# Rezoning Transportation Analysis

Petition Number: 2020-120

General Location Identifier: Tax ID (02962106)

Date	Description
09-11-20	First Review

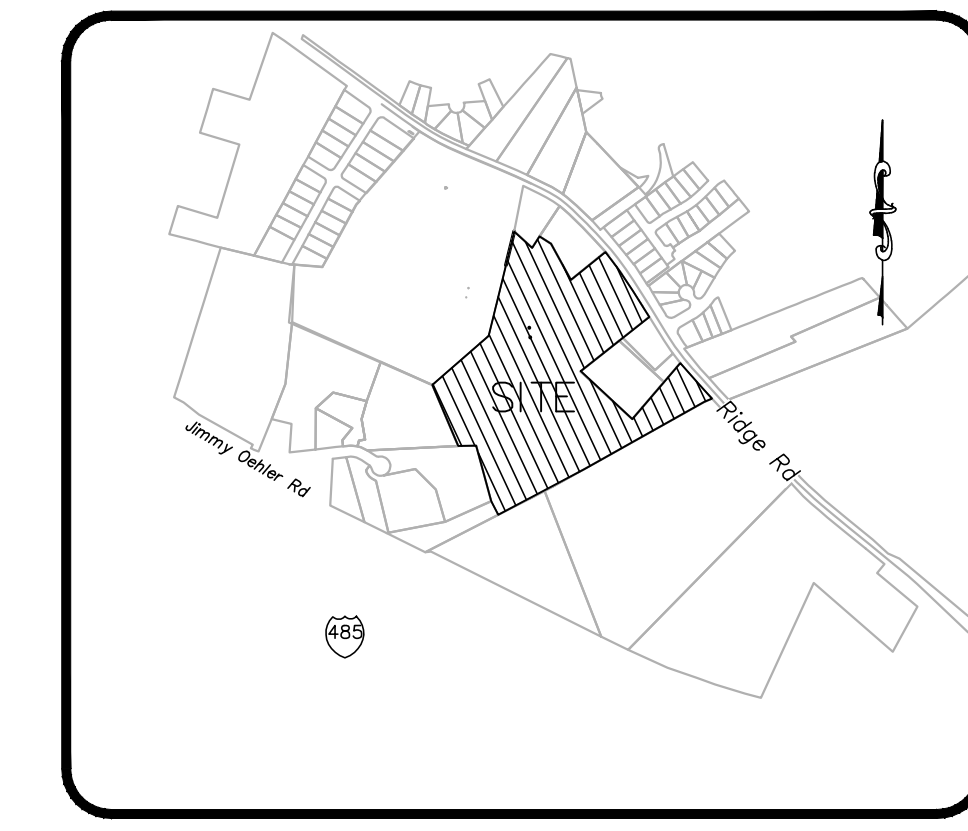
- a. **Ridge Road:** Match the future location of curb and gutter to the Prosperity Hucks Area Plan cross section, as shown below. Pavement widening should occur asymmetrically to the south of the proposed petitioner's site, since the parcel across Ridge Road to the north of the Redwood Ridge Road Subdivision is a mitigation site for I-485 construction and is protected by a conservation easement. Please refer to SDRMFR-2019-00041 - Redwood Ridge Road to tie-in the proposed streetscape into the approved Redwood Ridge Road Subdivision plans. The cross section from the Prosperity Hucks Area Plan may be modified to substitute the 10-ft sidewalk for a 12-ft multi-use path, in accordance with Charlotte BIKES.

Label and dimension the curb and gutter from the centerline for each road.

2. **Traffic Study** A Traffic Impact Study is not necessary for the complete review of this petition due to the site generating less than 2,500 daily trips. If during the permitting process the site generates more than 2,500 daily trips, then a traffic study will be required.
3. Revise the site plan and conditional note(s) to include the street network approved within the recently approved by-right subdivision project: **SDRMFR-2019-00041 - Redwood Ridge Road**, to confirm that proposed Street B will connect to future Lilac Grove Drive.

4. Revise the site plan and conditional note(s) to commit to constructing a left-turn lane on Ridge Road at proposed Street A. Please refer to rezoning petitions **2020-051**, **2020-075** and the recently approved by-right subdivision project: **SDRMFR-2019-00041 - Redwood Ridge Road** to coordinate roadway designs to provide a consistent three-lane cross section on Ridge Road.
